Gatwick Northern Runway

TR020005

National Highways Comments on any Submissions Received by Deadline 2

April 2024

SCALE @ A3 1:34,000

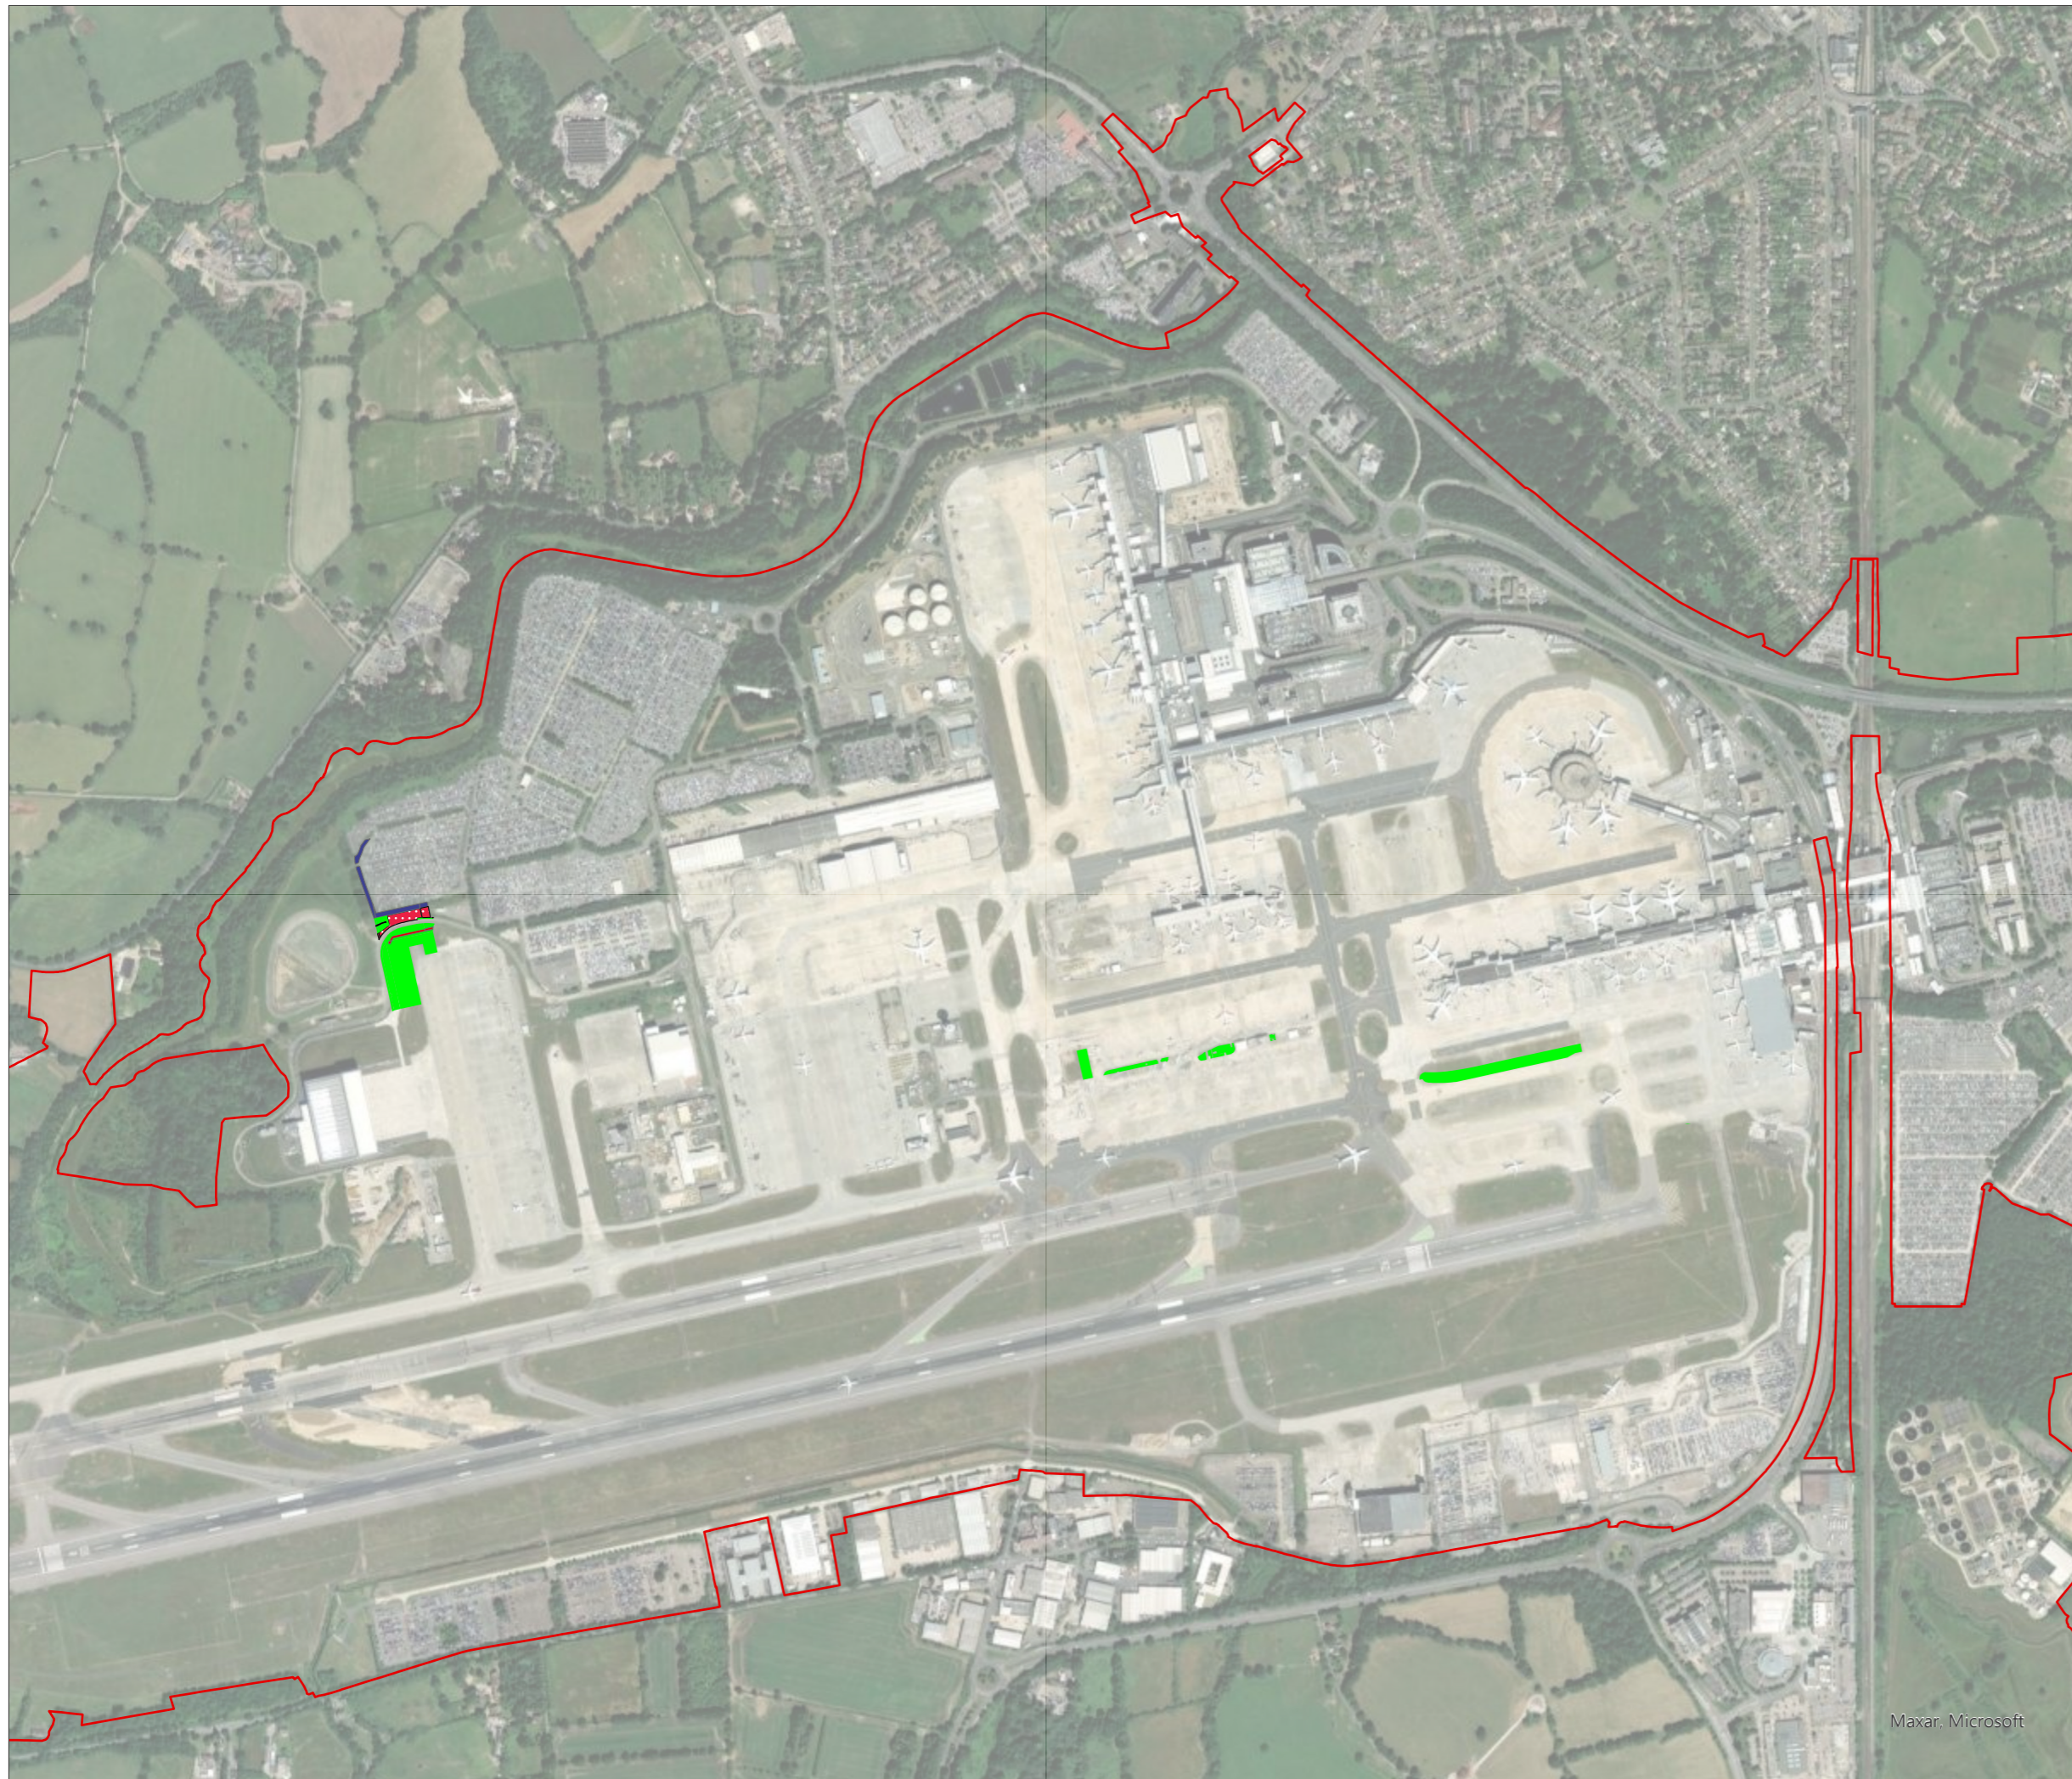
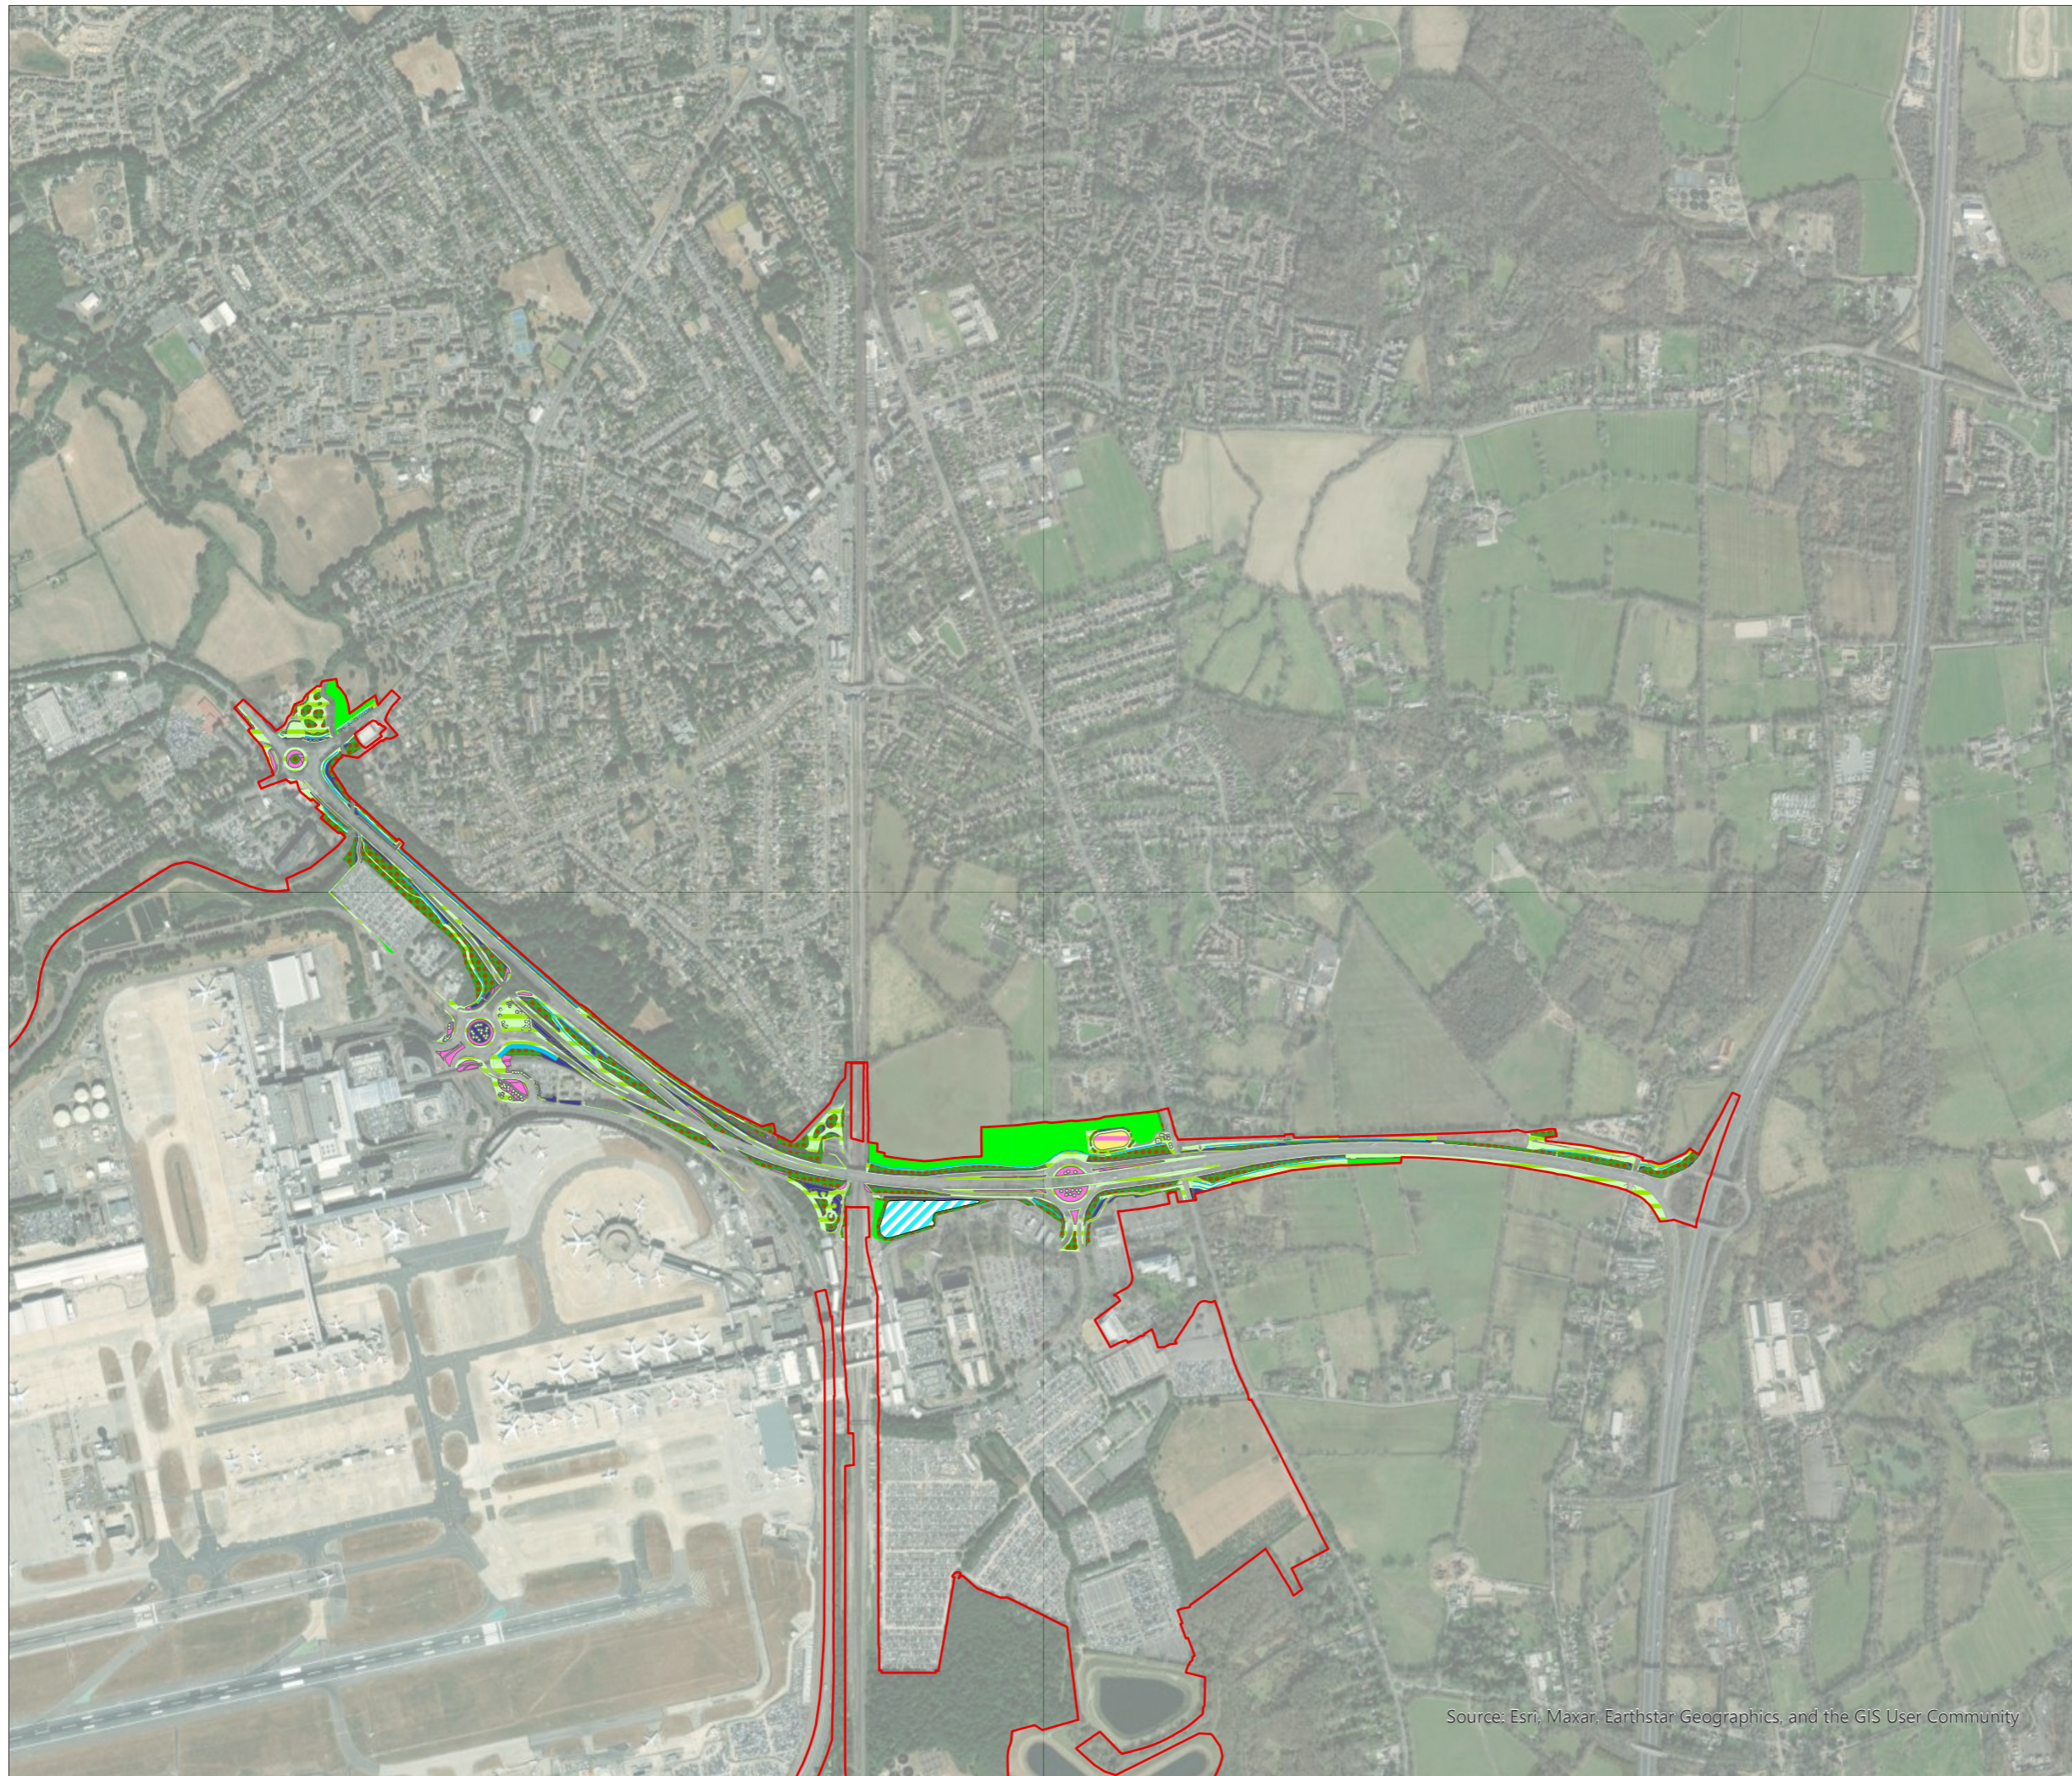
5.3 Environmental Statement Appendix 9.9.2: Biodiversity Net Gain Statement (Tracked) – Version 2			
Section 3.1.2 and Table 3.2.1	REP2-029	<p>The description below (Table 3.2.1) relates to each row in the baseline of the Defra Metric 4.0 for the areas impacted (Annex 1).</p> <p>The total area which would be impacted is 230.99 ha (Table 3.2.1).</p>	<p>National Highways requests that the Applicant confirms whether Table 2.5.1 on page 2 of the updated Biodiversity Net Gain Statement should instead read as Table 3.2.1 as referred to in Section 3.1.2.</p> <p>In addition, National Highways queries whether the total area which would be impacted noted in Section 3.1.3 remains as 230.99 ha given the areas that have been added as part of the updated document. It is further noted that Table 3.2.1 currently amounts to a total of 241.6 ha so National Highways requests clarification from the Applicant as to the true value of areas impacted.</p>
